Landscape Plan 7301 Cole View

FINAL LANDSCAPE PLAN

BEAR CLAW
7301 COLE VIEW
CLAREMONT BUSINESS PARK LOT 32-2
EL PASO COUNTY, COLORADO SPRINGS, CO 80915

COUNTY FILE NO. PPR-07-007
PCD File COM2413

FINAL LANDSCAPE PLAN

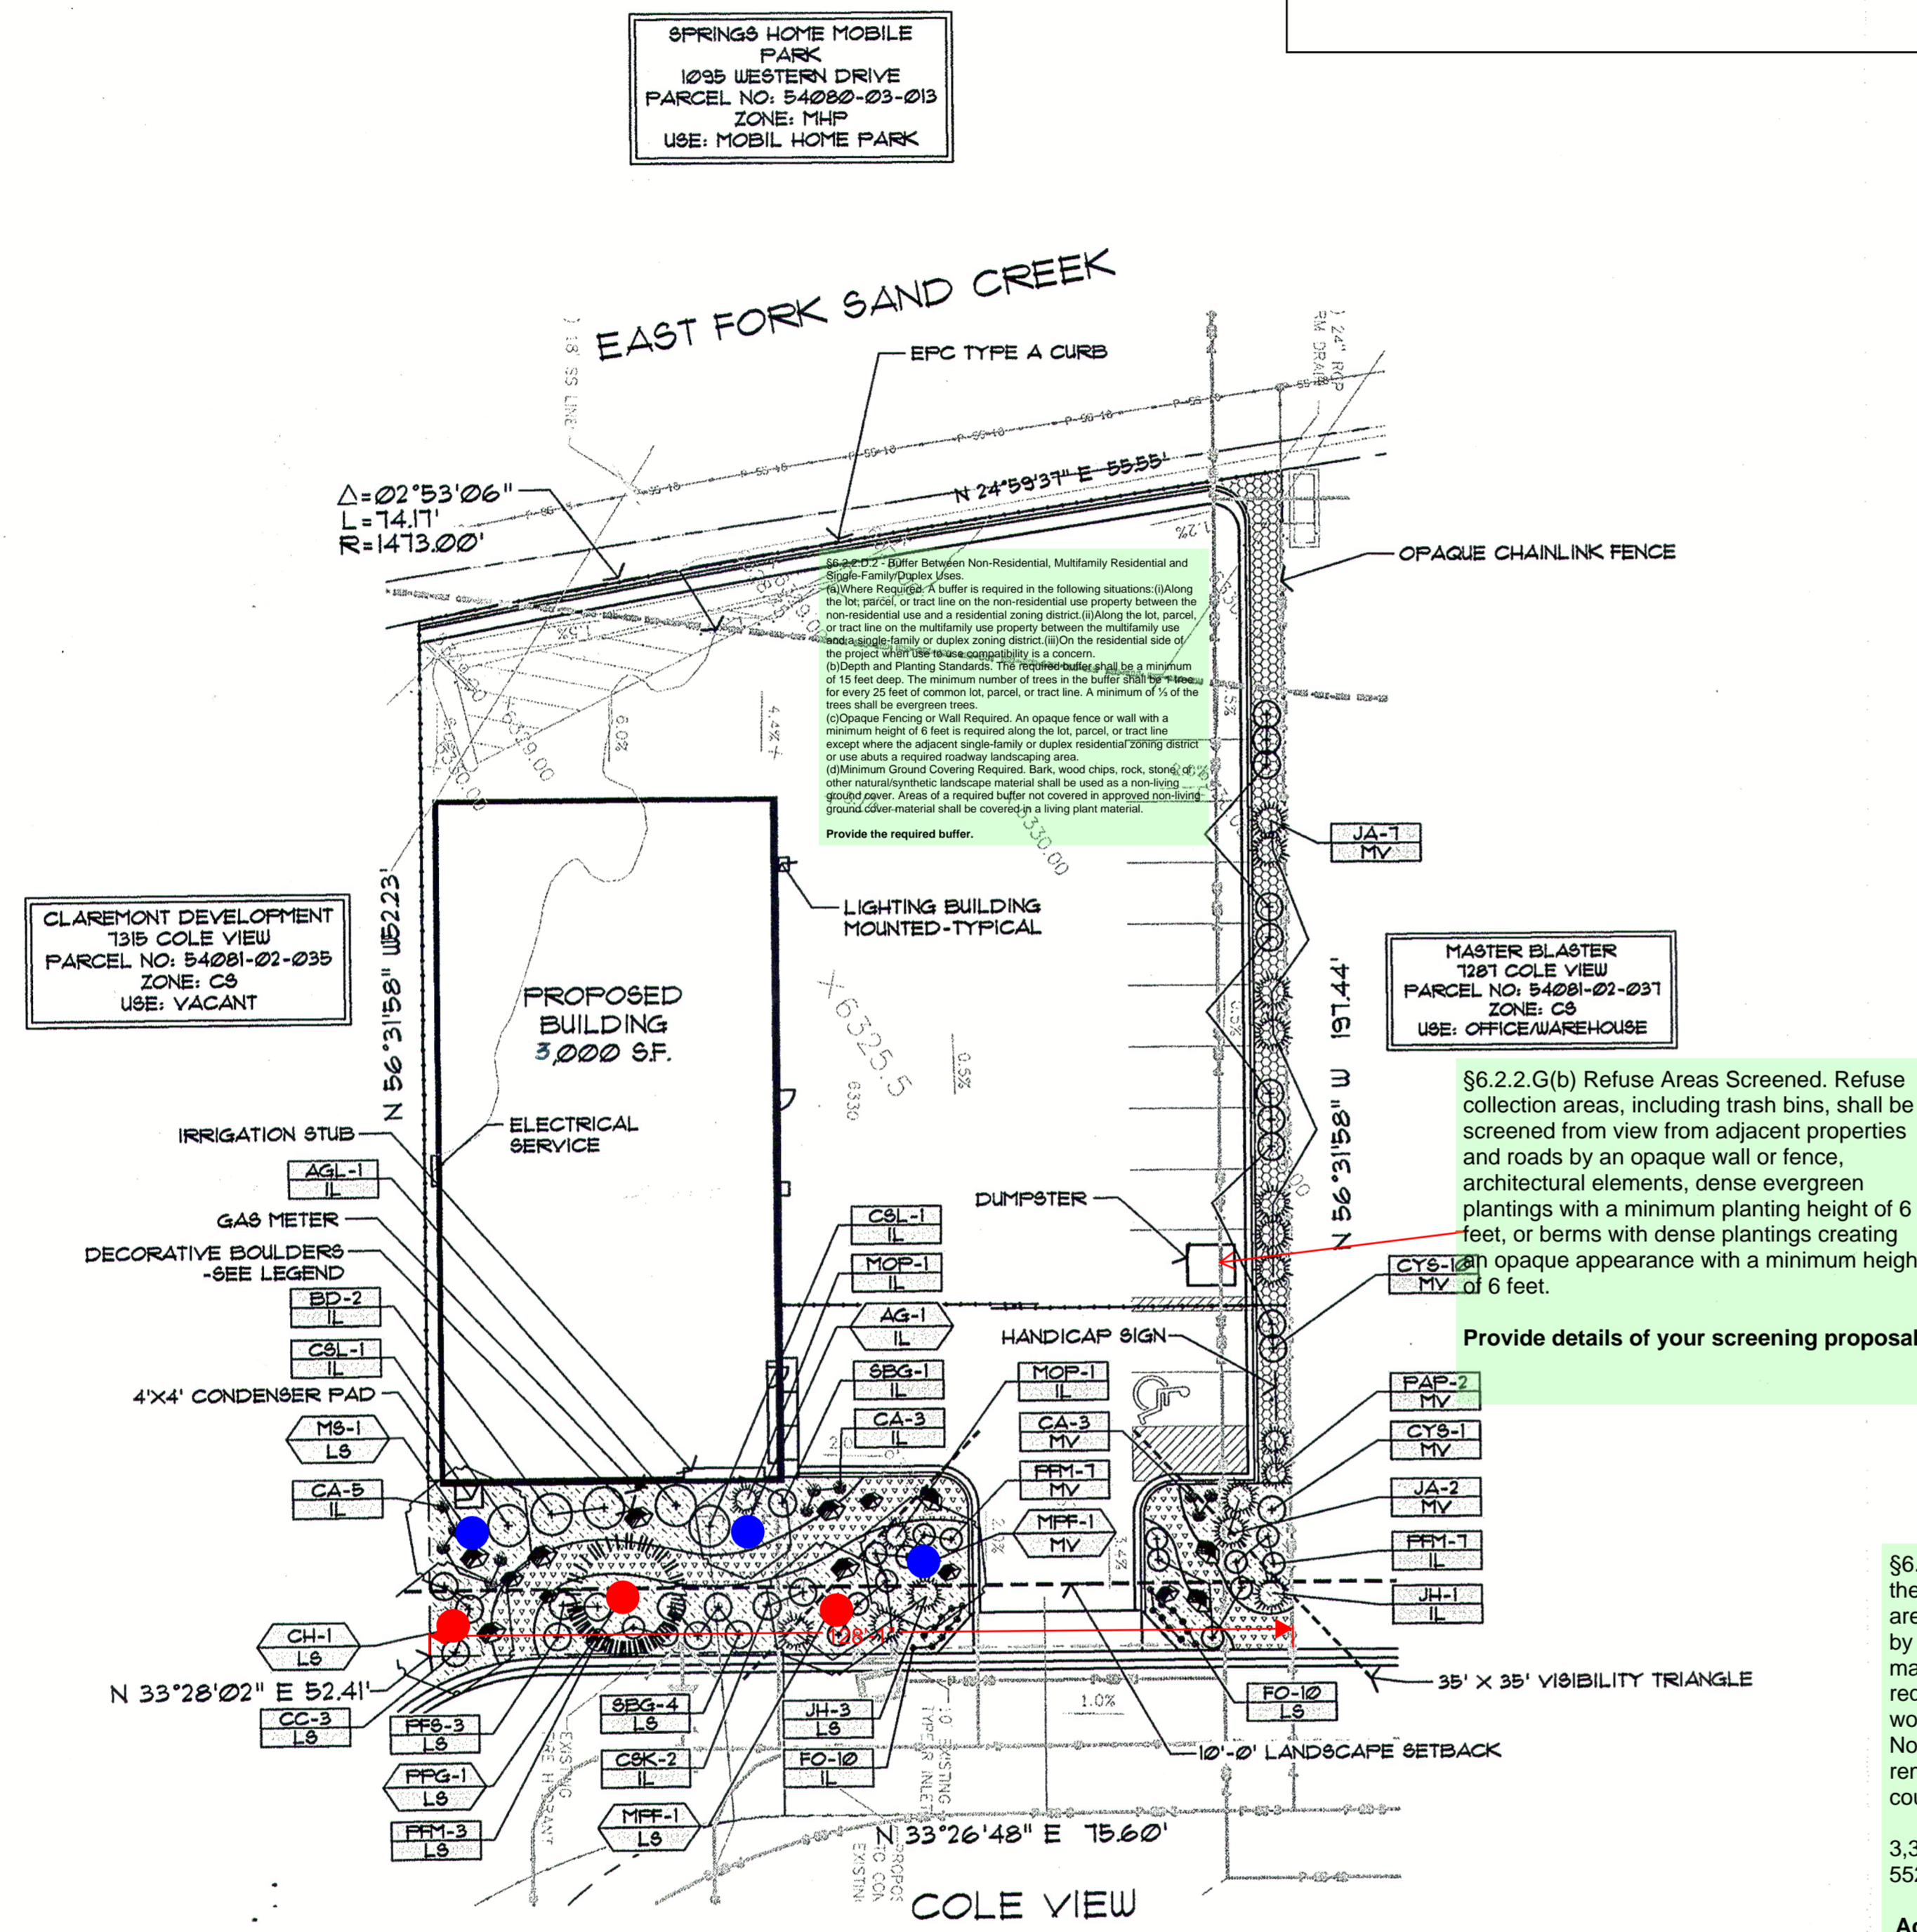
Where? All six trees counted in the plant schedule are depicted in the westerly landscape area.

Per previous comments:
§6.2.2.F.2 - Required Ground Cover. Unless utilizing the principles of xeriscaping, required landscape areas shall include a minimum of 30% ground cover by living or synthetic grass or other living plant materials at maturity. The remaining 70% of the required landscape area may be covered with bark, wood chips, rock, stone, or other landscape materials. No other areas within required landscape areas shall remain bare. The foliage crown of trees shall not be counted in meeting the ground cover requirement.

3,300 x .3 = 990 sq ft of plant cover required
552.17 sq ft of plant cover proposed

If you feel that you can not meet the requirements of the code, per §6.2.2.A.4 attach a letter with your next submittal requesting a substitute landscape design. The letter shall address in detail, how your design meets the purpose of the code, promotes the concepts contained in the Landscaping and Planting Manual, and provides an equivalent benefit to the community and environment as would otherwise be achieved by meeting the specific requirements of the code.

Add an additional 437.83 sq ft of plant material
